M54 to M6 Link Road
TR010054

**8.8 LIU(I) Draft Statement of Common
Ground with Ian Simkin & Adrian
Simkin**

February 2021

**M54 to M6 Link Road
Development Consent Order 202[]**

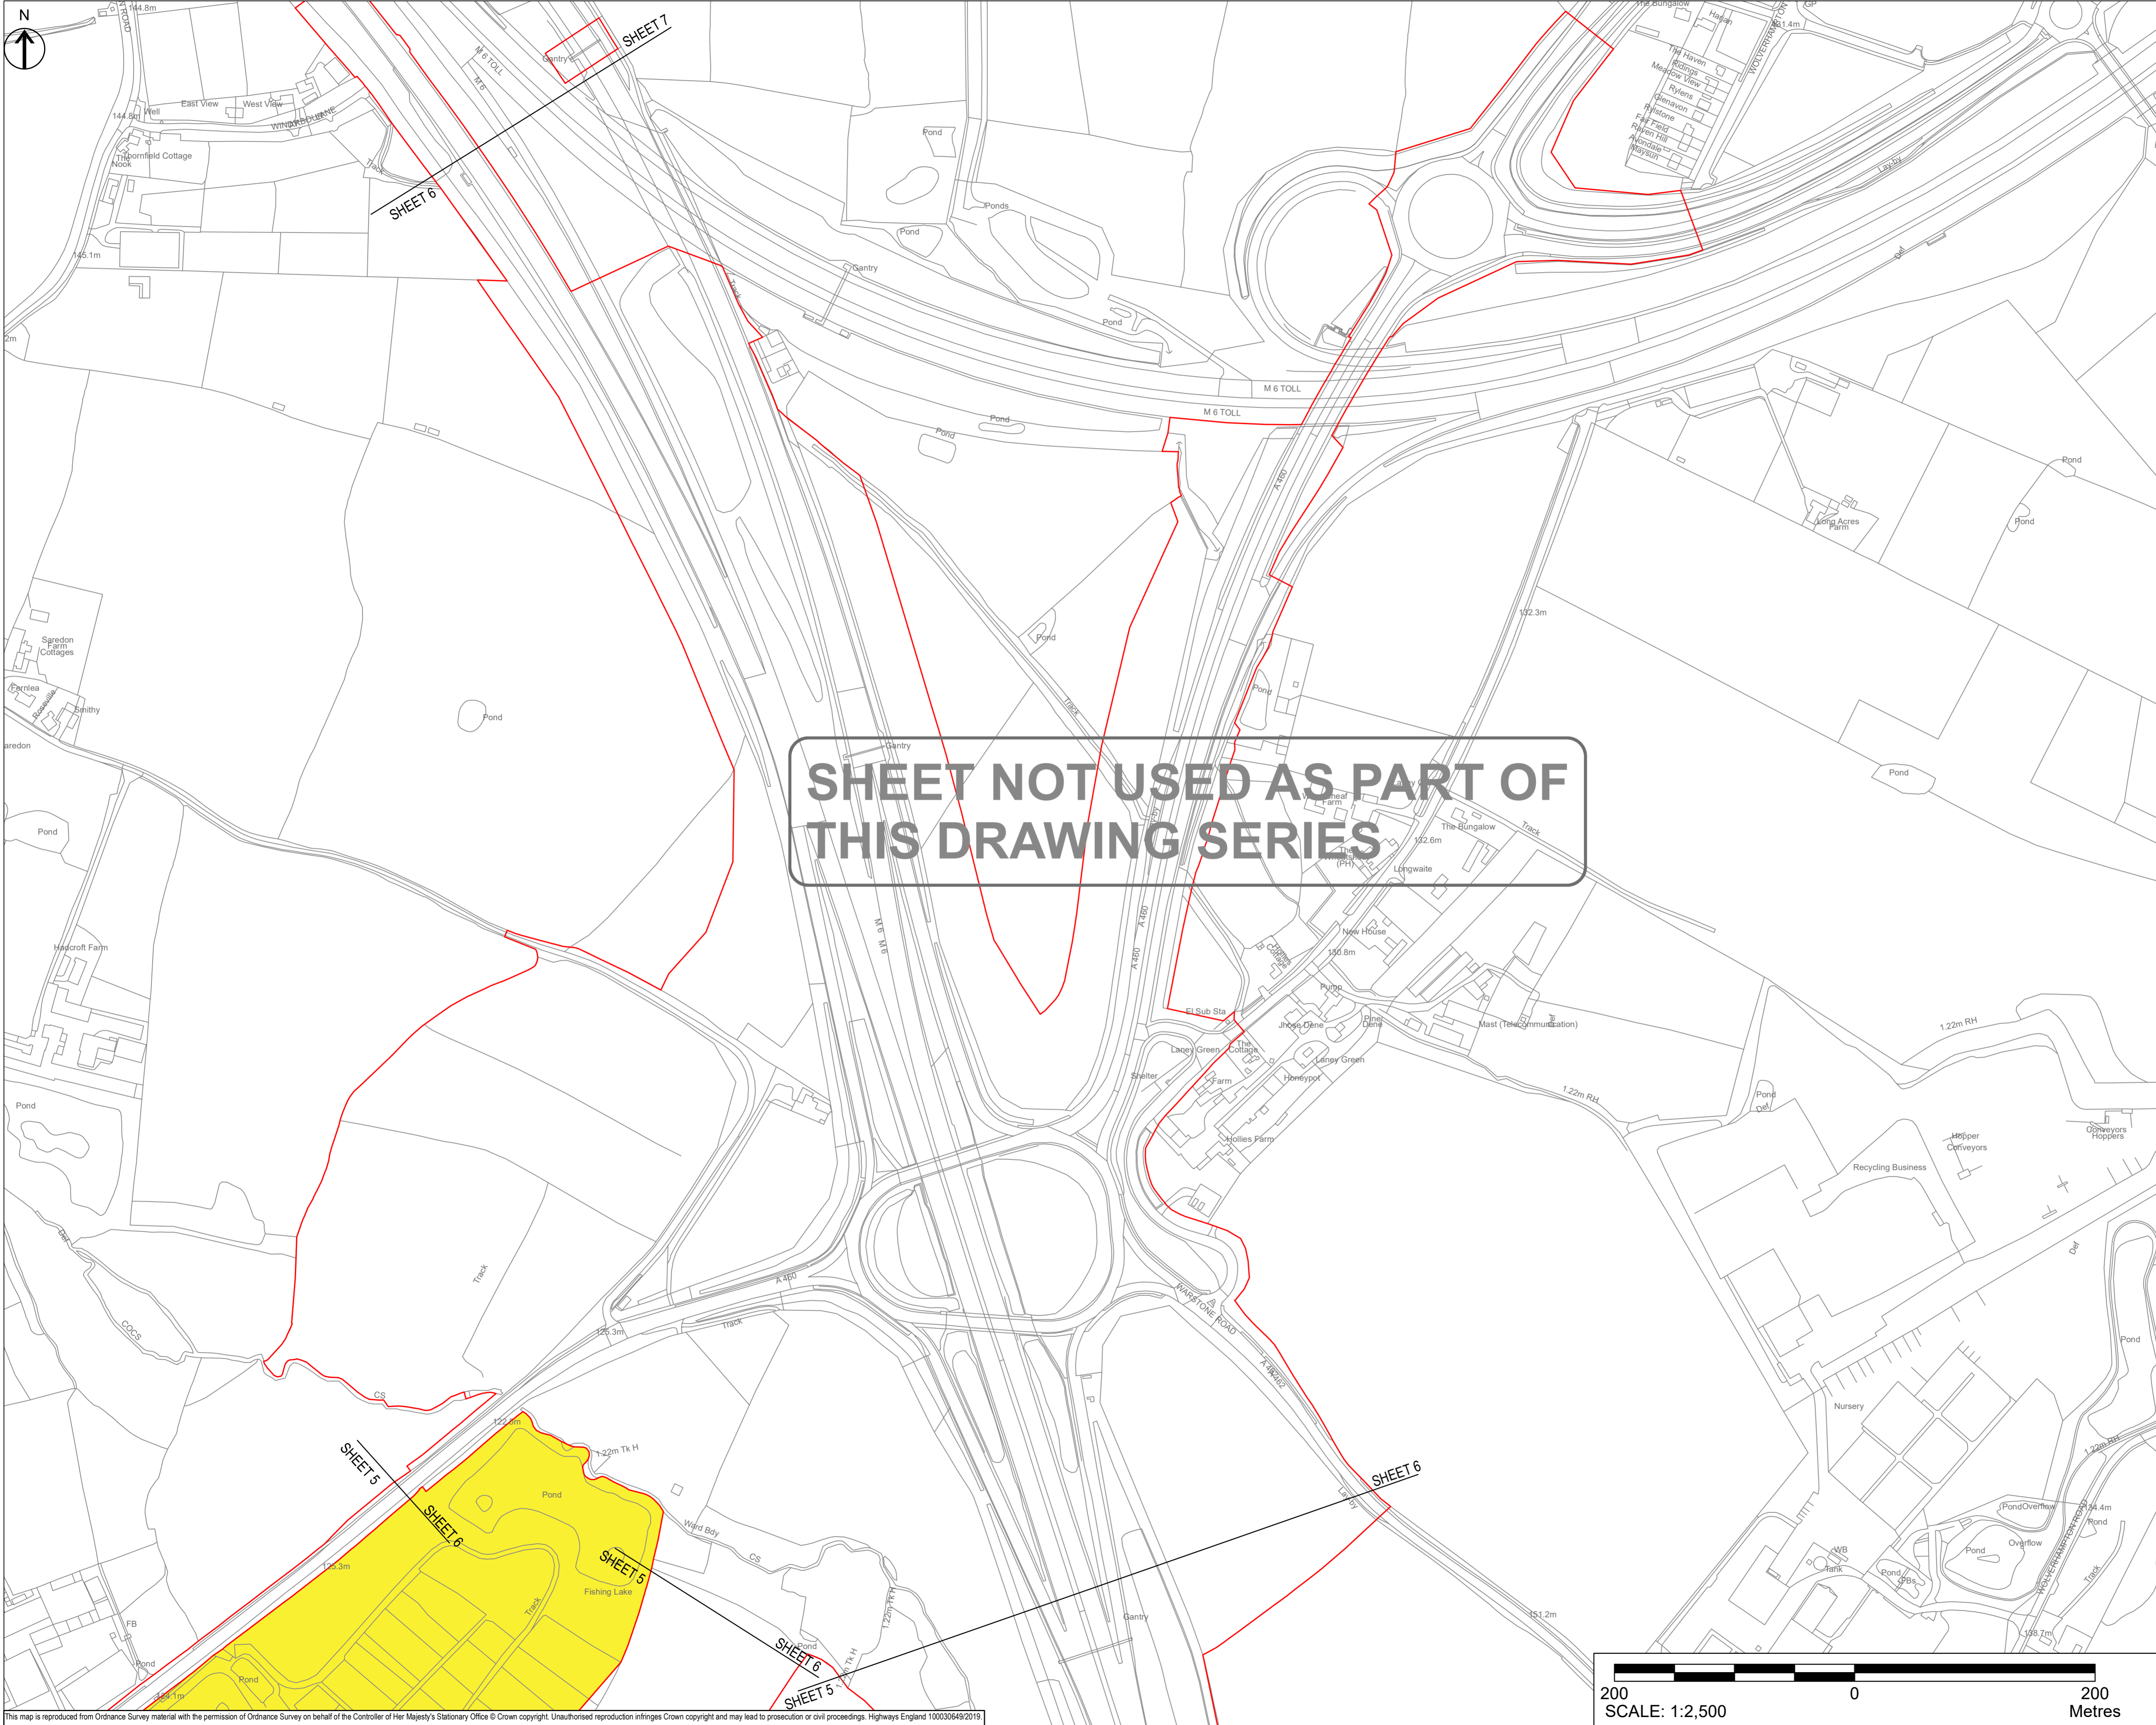
Land take requirements	Land agent's Relevant Representation RR-033 and letter received from Bagshaws	Messrs Simkin object to the acquisition of [6/23] where there is the proposed acquisition of the entire road frontage of the field parcel along the A460 with no	Highways England will seek to retain access to the adjacent land from the lay-by. The land take along the A460 is required to accommodate any changes to the existing layby. As per the current scenario, 3 rd party land ownership will be maintained from the back of the lay-	Under discussion	High	High

dated 28/01/2020 Further discussed at site meeting on 16/12/20	provision for access and turning agricultural vehicles or for any other future uses.	by with access provided to match the current arrangement. Further to the site meeting on 16 December 2020 a draft arrangement has been drafted (refer to Appendix B) and is under discussion SCC has confirmed they are in agreement with the principle of this arrangement subject to agreement to stopping up the existing access from the layby.			
Grazing requirements	Letter from Bagshaws, 28/01/20. Also mentioned in land agent's Relevant Representation Further discussed at site meeting on 16/12/20	The new scheme boundary of 6/23 and 6/20a to be used temporarily in the road scheme, will negate the ability of the remaining field area to be used for arable production, due to the small and unworkable shape created. This field may accordingly only be suitable for grazing and as such will require the provision of a water supply. I&A Simkin confirmed that this plot currently has a water supply pipe fed from plot 6/29 and	Please note that plot 6/20a (as identified during the November 2019 Supplementary Consultation) is now plot 6/37 in the Land Plans (P02) submitted as part of the Application. Plot 6/37 (formerly 6/20a) is required temporarily for a working area alongside the existing slip road, which is to be realigned. Highways England will amend the existing water supply as part of the works to provide a like for like private water supply and will continue to discuss accommodation works with landowners as the project progresses.	Under discussion	High	High

New Access to plot 6/25	Discussed at site meeting on 16/12/20	I&A Simkin noted that the access to this field is off the back of the layby on the A462. Access can be problematic due to vehicles parking in the layby. I&A Simkin noted that construction access to the plot would be to the west of the layby and requested that this is made into a permanent access	Highways England confirmed that this may be possible subject to agreement with SCC (a draft arrangement has been drafted (refer to Appendix B)). I & A Simkin confirmed they would be happy with a single 5m gate as shown in Appendix B. SCC has confirmed they are in agreement with the principle of this arrangement.	Under discussion	High	High
Protection to temporary acquisition plots (plot 6/25)	Discussed at site meeting on 16/12/20	IS&AS asked if matting will be provided to protect the field prior to storing topsoil	Matting will be provided adjacent to the access to plot 6/25 from the highway. Pre and post condition surveys would be undertaken to ensure that the field is left in an equivalent condition to currently	Under discussion	High
